From: Rhiannon Lloyd
Sent: 09 July 2025 13:52
To: Planning.Responses
Subject: FW: FG/64/25/HH - 4 Sea Lane
Attachments: Sea Lane_PL03E.pdf

FG/64/25/HH - 4 Sea Lane

With reference to the above and my earlier email, I have pleasure attaching the updated drawing showing the carport in context with the house, drawing PL03E for substitution of the drawing PL03D currently on file.

25.313 Drawing: **PL03E**

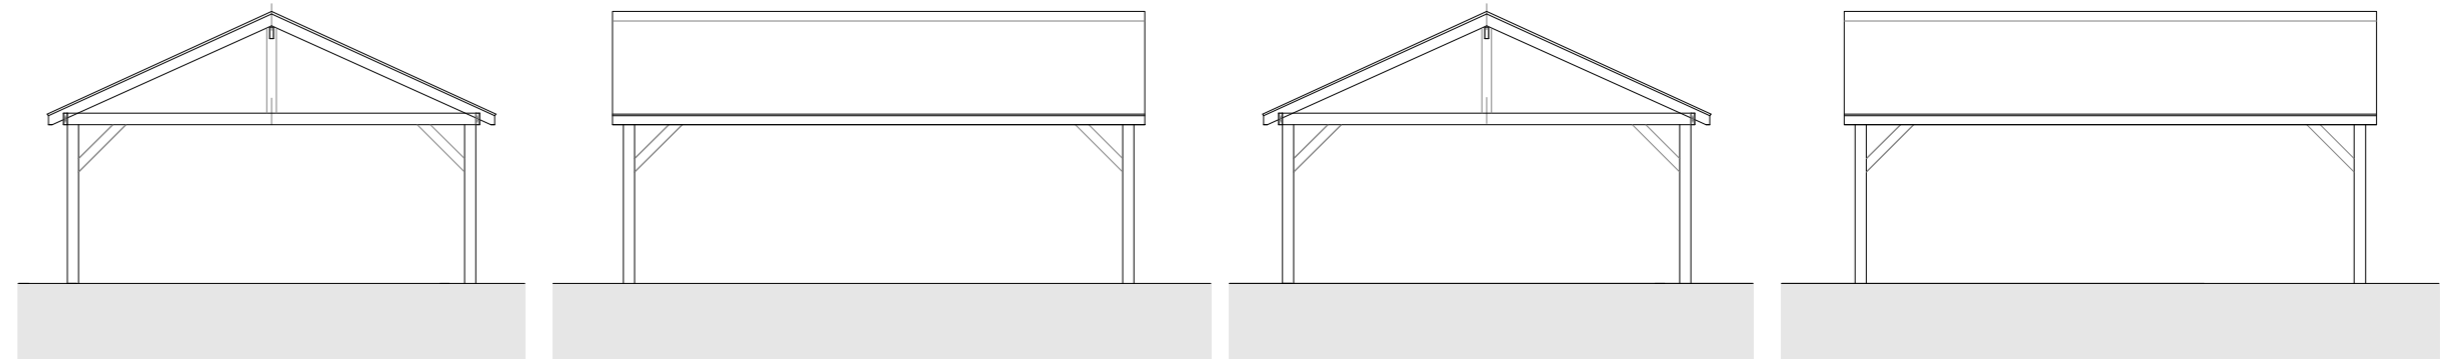
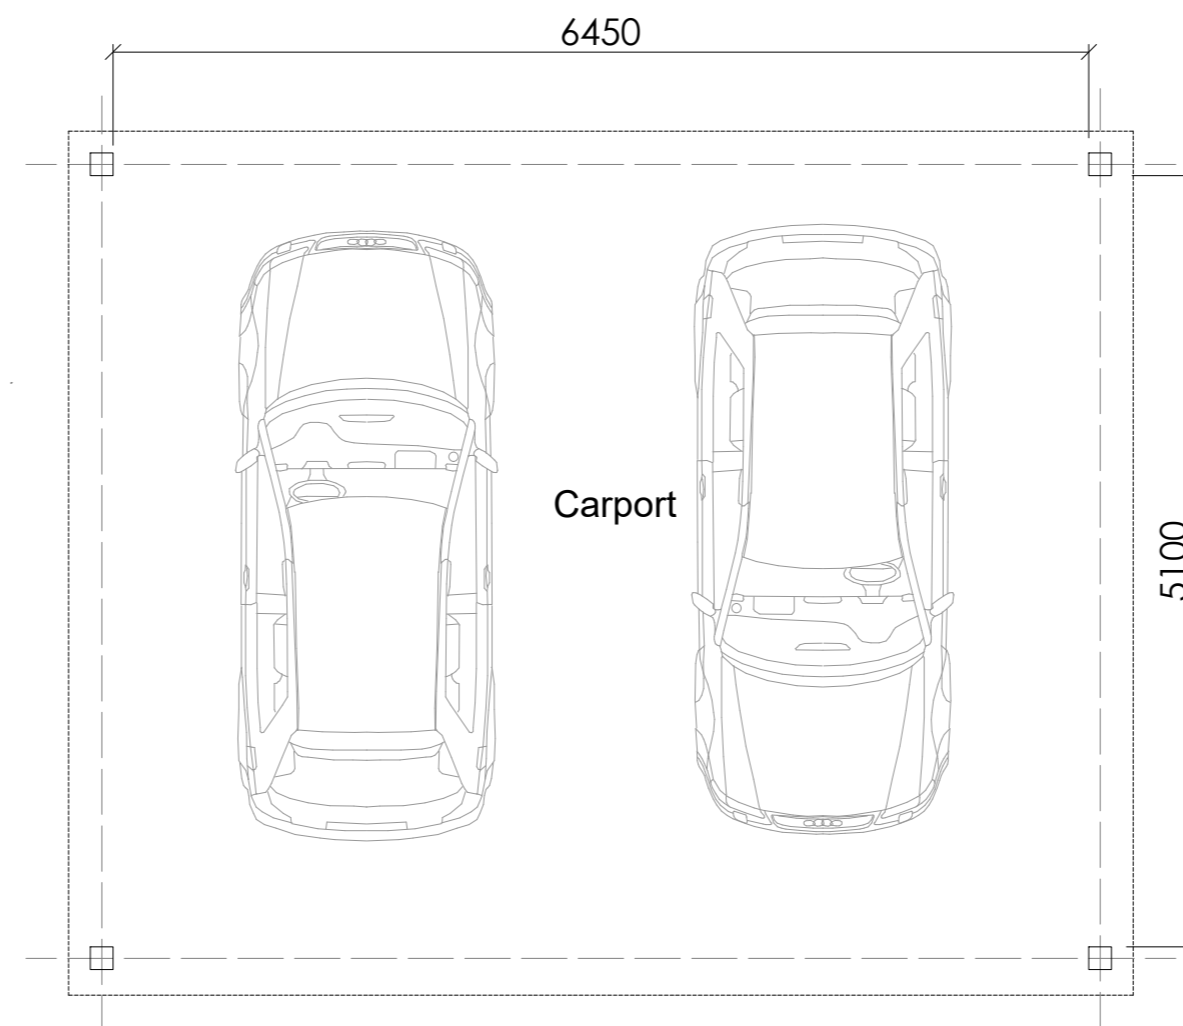
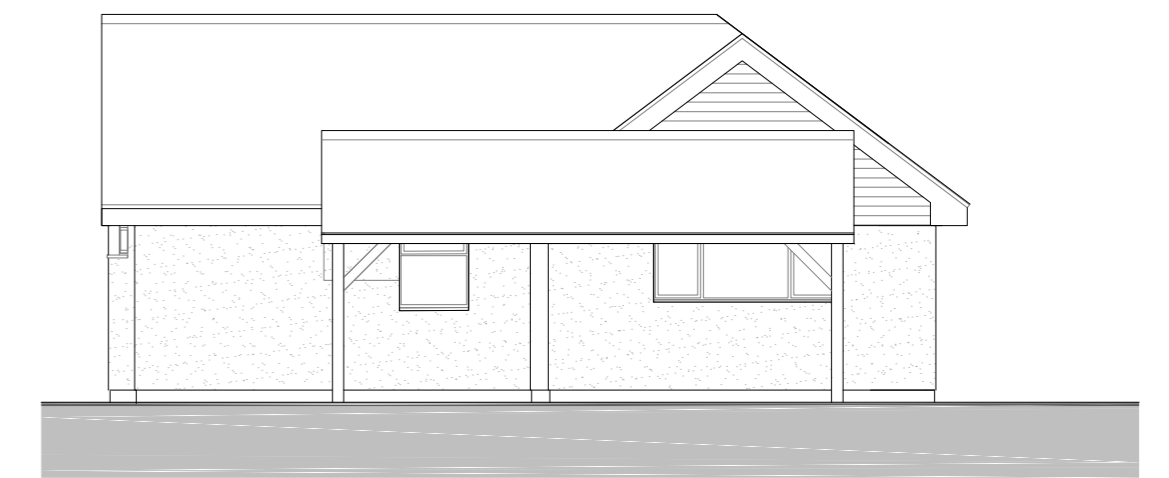
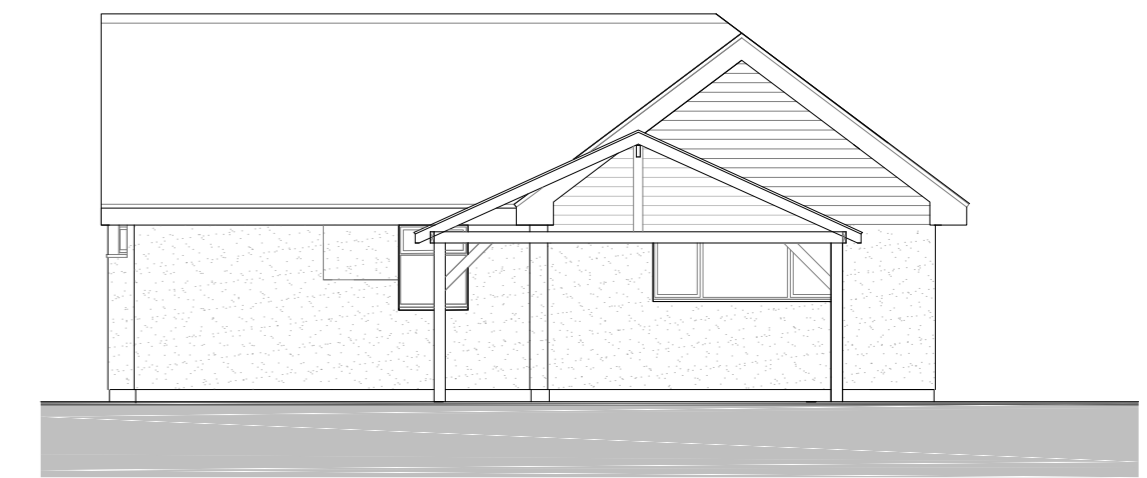
Following on from my earlier email and in light of the neighbour's comments, I have checked my drawing and realise that the site plan shows the roof configuration correctly, with the ridge running North-South, but my drawing PL03D needs changing as the elevations show the ridge running East-West.
